File: 100382.003 – R0

**Re: Geotechnical Review of Site Grading and Servicing Plan
Proposed Residential Development, 1240 Carling Avenue, Ottawa, Ontario**

For review, GEMTEC was provided with Drawing No. G-1 – 'Proposed Site Grading and Servicing Plan', prepared by T.L. Mak Engineering Consultants Ltd, dated April 2023.

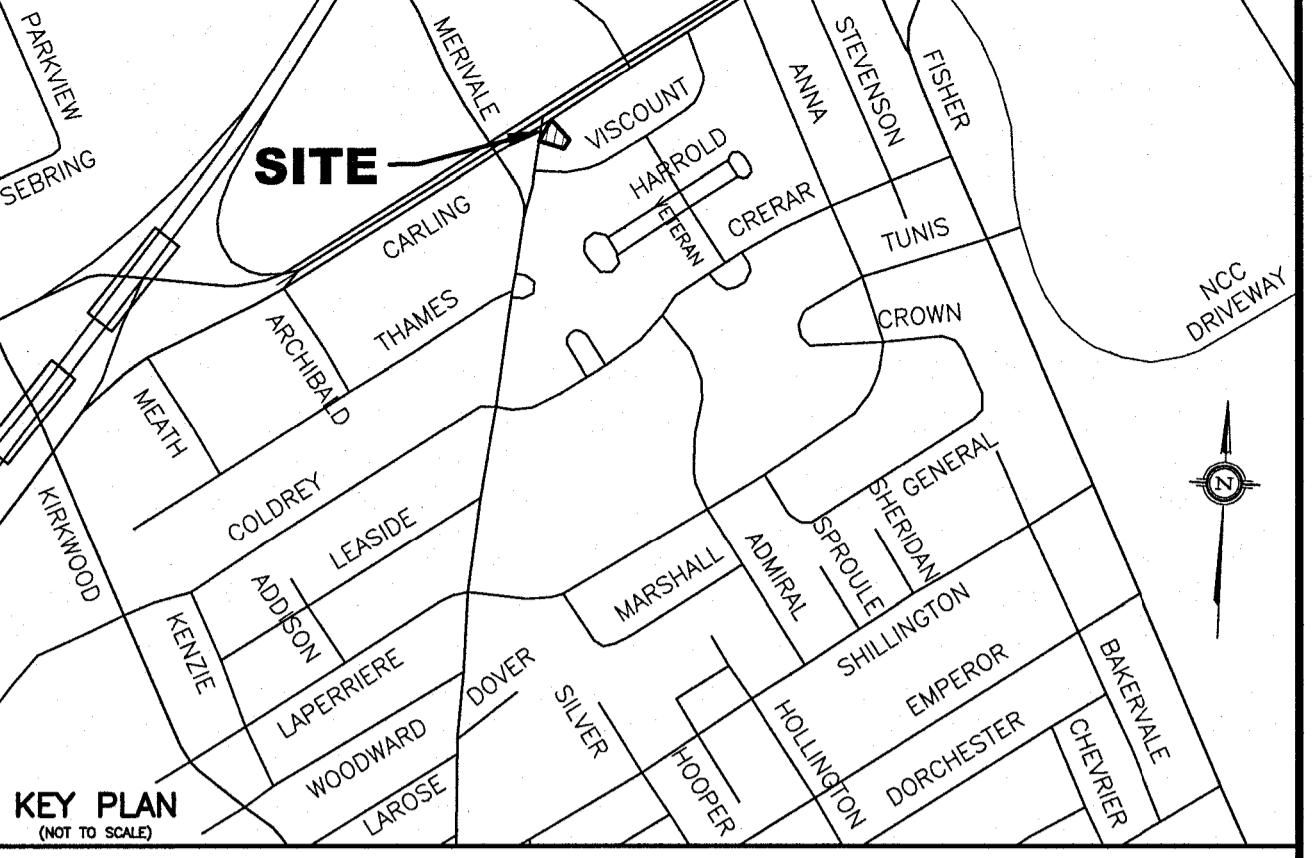
The subject plan indicates that the underside of footing elevation will be below the groundwater table and, further, at an elevation that is too low to allow for the footing perimeter drain to connect to the municipal storm sewer and allow drainage by gravity. As such, a sump pit/pump will be installed to convey groundwater from footing level to the storm sewer level. The plan further indicates that the developer should verify the normal high groundwater table prior to proceeding with construction, adjust design details according to the results, and obtain necessary permits accordingly.

During the course of the geotechnical investigation in January 2023, the groundwater level was measured at about elevation 73.8 metres (geodetic) (about 0.4 metres above the elevation of the underside of footings of the proposed building). As indicated in the geotechnical report, the measured groundwater level may not represent the highest groundwater level, past, present, or

future. It is GEMTEC's recommendation that the groundwater level be measured ahead of construction from within the monitoring well that was installed during the geotechnical investigation, and that the current design, contingency measures (e.g., backup generator, additional pump), permitting requirements, etc. be reviewed based on the existing and additional groundwater level information. Given that the current and subsequent measurement may not represent the highest groundwater level, ideally a groundwater monitoring program would be undertaken for a minimum period of one year. The data from such a program would provide a more accurate, although not definitive, indication of the typical, seasonal high groundwater level.

The proposed depth of the service laterals (water, storm, sanitary) will be provided with less than the required depth of earth cover required by the City of Ottawa. As indicated on the plan, appropriate measures (e.g., insulation) should be applied to mitigate the condition and provide adequate protection from frost/freezing.
